Application No: AB/135/20/OUT

Site Address: Land at Ford Road Arundel

Description of works: Outline application with some matters reserved (except for access) for the development of 90 dwellings & associated amenity land. This application is a Departure from the Development Plan, affects the setting of listed buildings & affects the character & appearance of the Arundel Conservation Area.

Thank you for your internet representation made on 2nd January 2021 which has been recorded as an objection with the comments as follows:

Parameter Plan - Movement

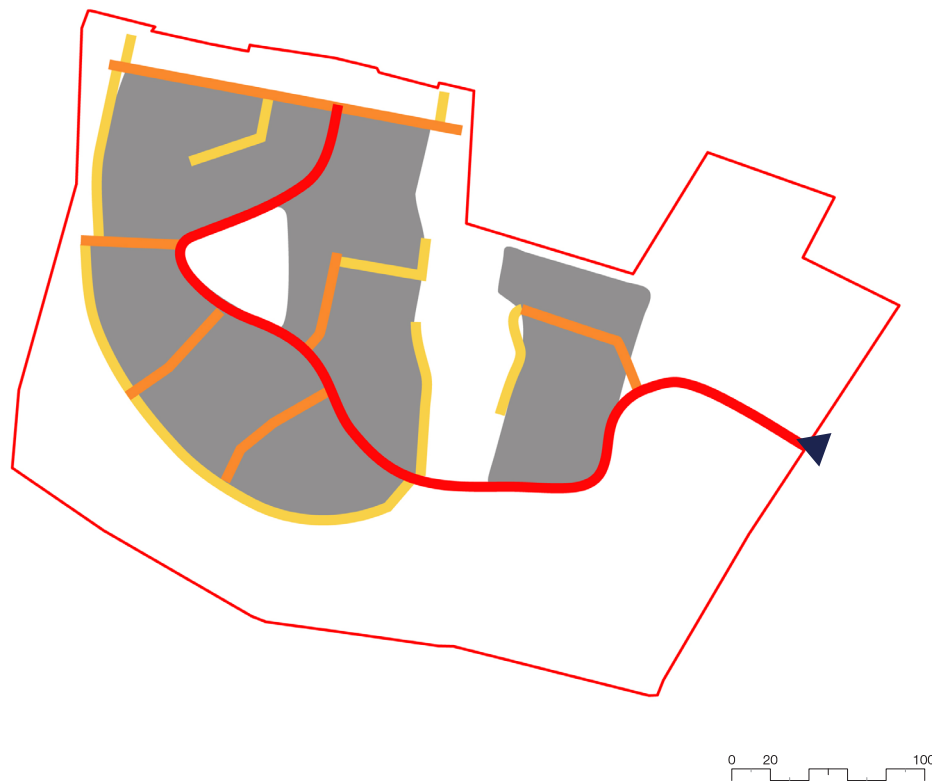
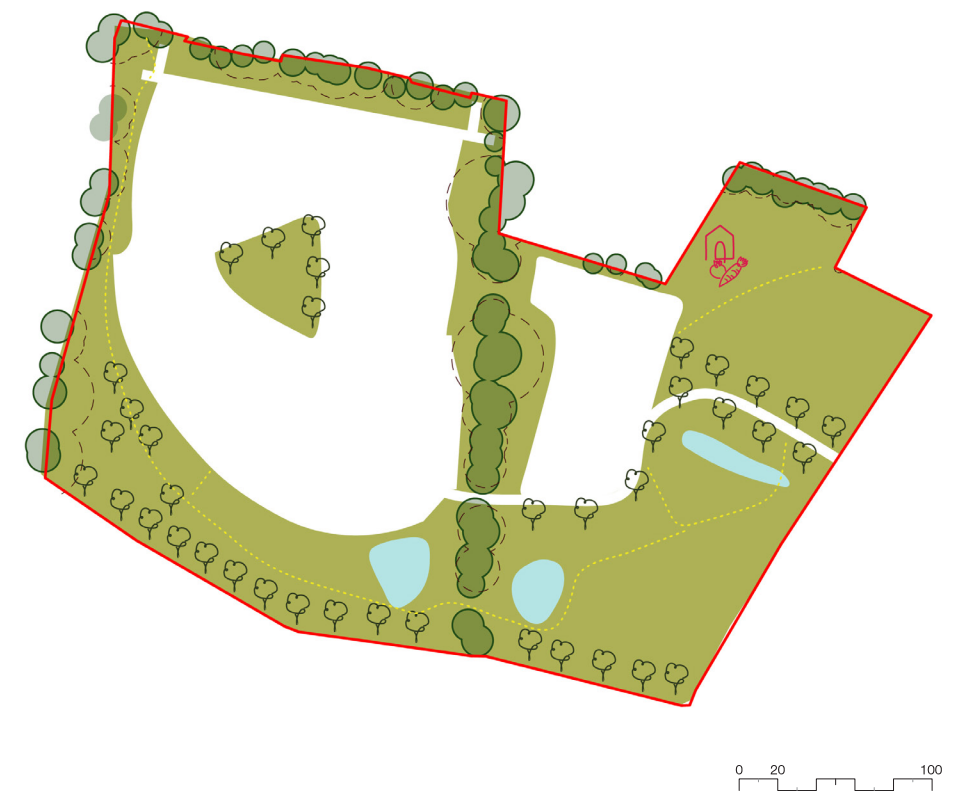
(3) minimising the extent of new street lighting, subject to safety aspects. Is it really necessary to provide street lighting from the junction of Ford Road up to the start of the residential development in the eastern field ? If it is necessary then street lighting of appropriate design, height, column colour (dark green rather than black), luminosity and light source needs to be required, given the rural setting.

Drawing No.	Rev	Title	Description	Scale
173483-002	C	Land at Tortington, Arundel	Site Access Arrangement	As Shown

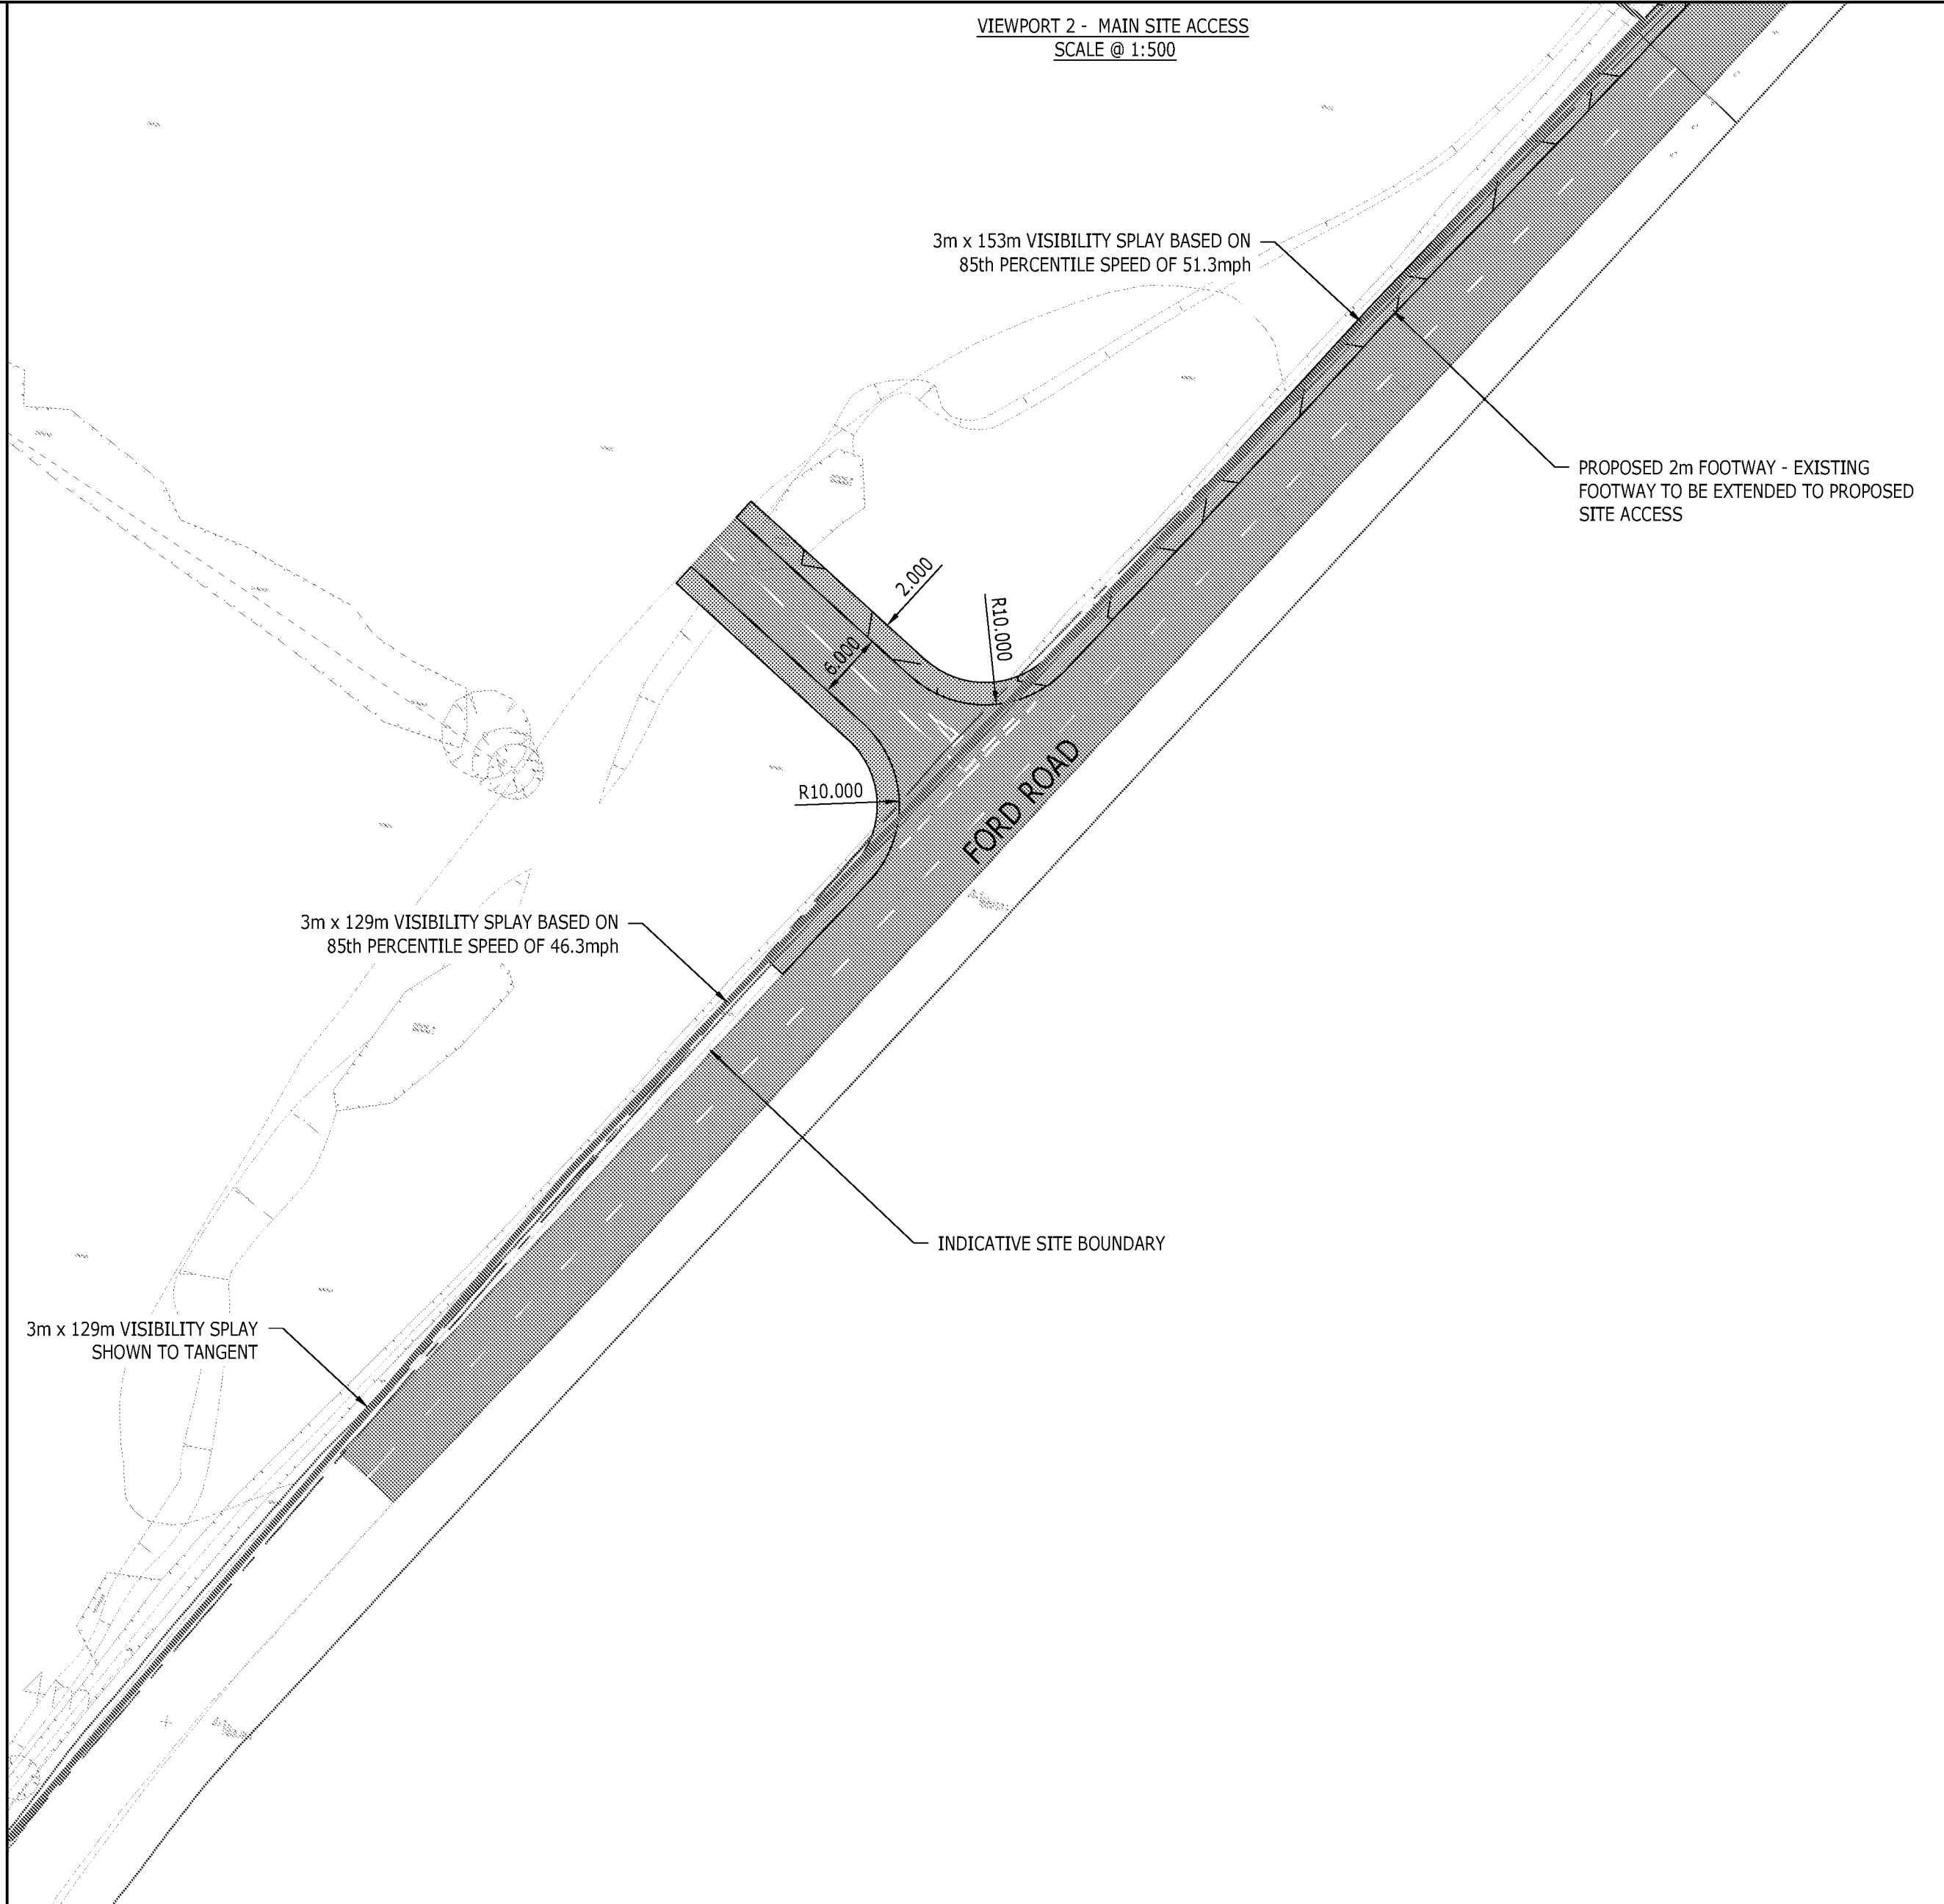
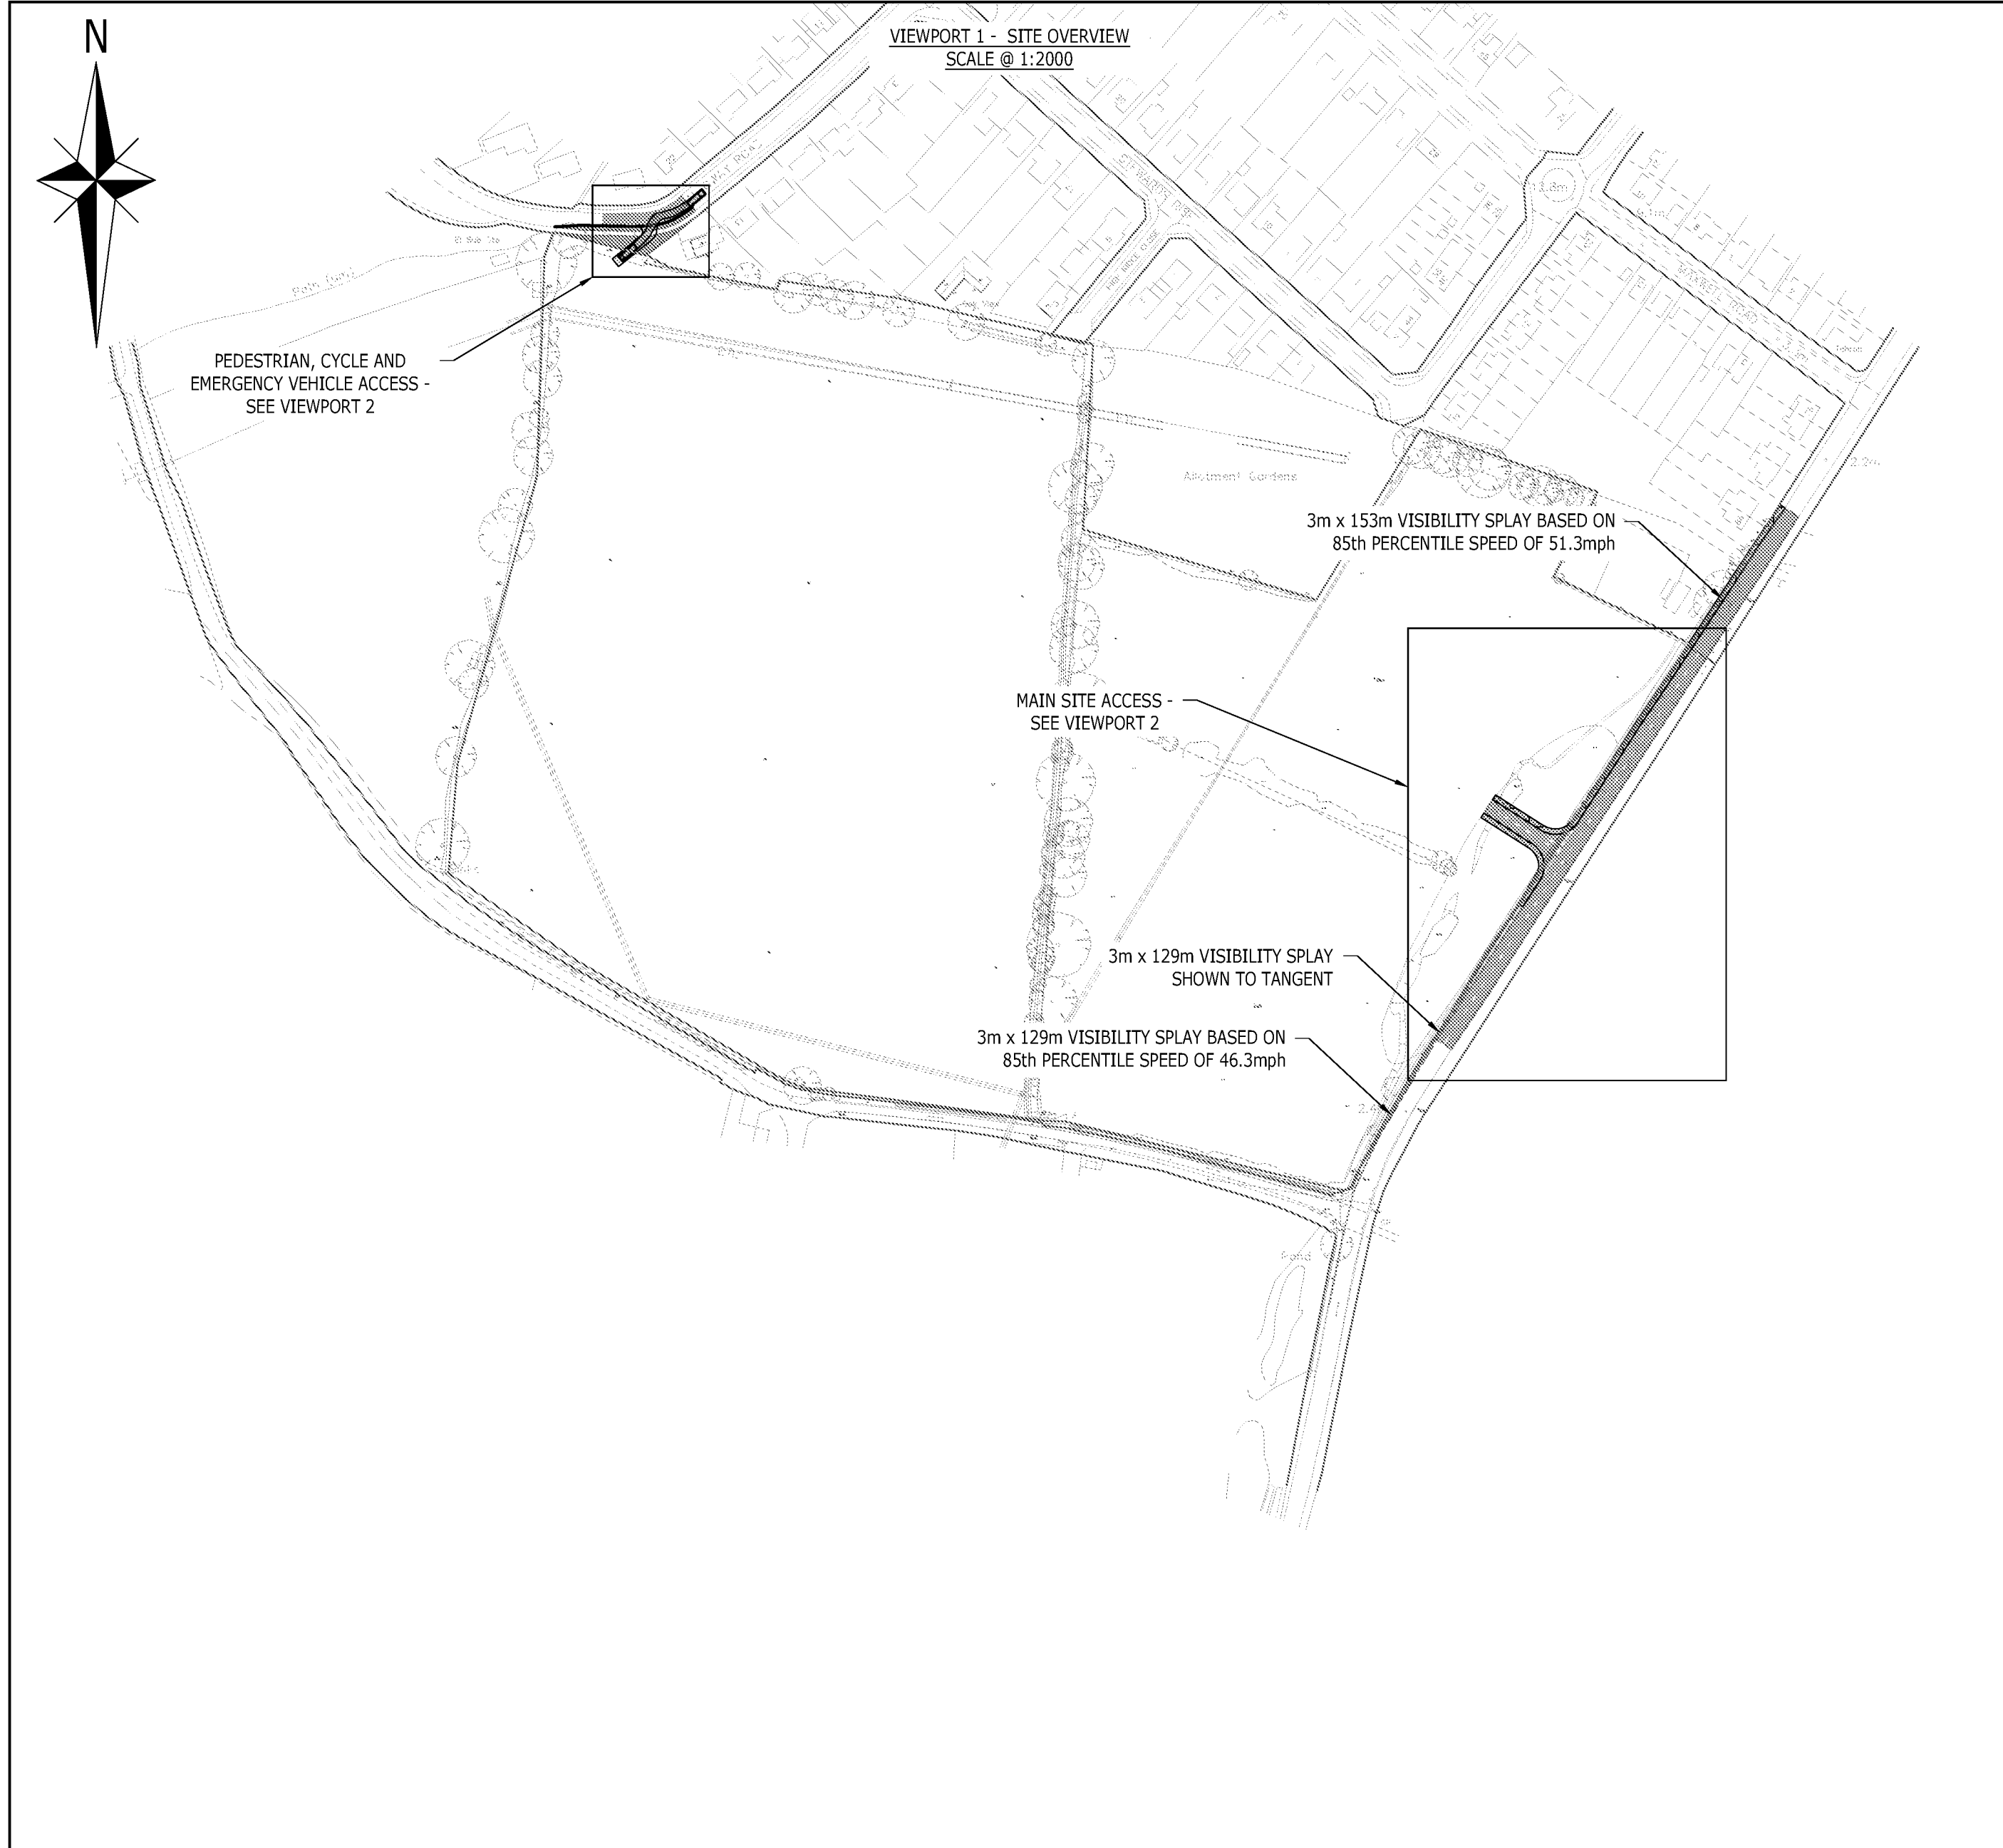
In Ford Road the distinctive and abrupt junction between open countryside and built-up area is an appropriate and attractive feature of the southern entrance into Arundel. The formation of the new access road with its disruption to the roadside hedgerow line, and its attendant features such as footpaths and street lighting. etc all leading up to residential development which will undoubtedly be seen on the higher ground level will materially detract from the nature and quality of that important entrance and also, of course, the rural setting of the town.

All matters are reserved except for access but there is limited detailed information concerning the design and materials of the new road junction (and the attendant footpaths) with Ford Road. In addition, it is not entirely clear whether the proposed visibility splays mentioned in the Transport Assessment document will involve the loss of parts of the existing hedgerow or not. If there is a loss then clearly it will be important that replacement planting of the same species is provided along the back of the splay lines in order to maintain as much continuous hedge line as possible.

(2) ensuring that the surface materials and finishes of the new access, roadway, footpaths and kerbing are appropriate to the rural setting.
